From: Maria Tomalova <Maria.Tomalova@arun.gov.uk>
Sent: 15 December 2020 09:31
To: Planning.Responses <Planning.Responses@arun.gov.uk>
Subject: FW: BR/270/20/DOC- 99 Victoria Drive Bognor Regis

Engineers Comments Regarding Condition 5- Surface Water Drainage

Client	Sam Quinn
Drawing Title	Construction Details

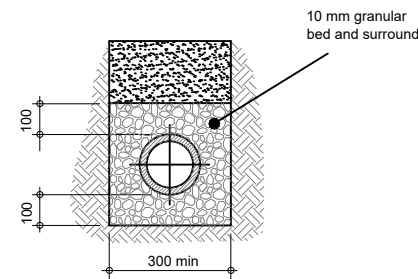
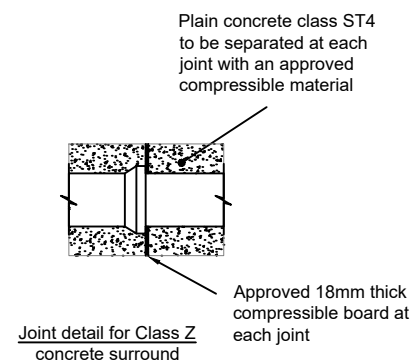
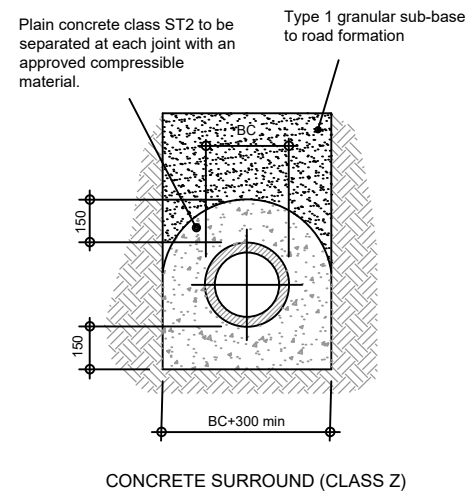
- Please can the applicant update the permeable paving detail to be specific to the site, i.e. to show the minimum required depth.
- Please can it be confirmed/ detailed on the drawings what depth the perforated rings are to extend up to.
- We are unclear on why the ring soakaways extend to the depth they do when this depth does not appear to be required and the invert level will be down far below the peak recorded groundwater level. Please can the applicant provide some commentary on the design.

We recommend that Condition 5 is discharged. Please reference the following drawings in any approval:
2104-SK5 SW Drainage Layout
2104-SK2 Construction Details
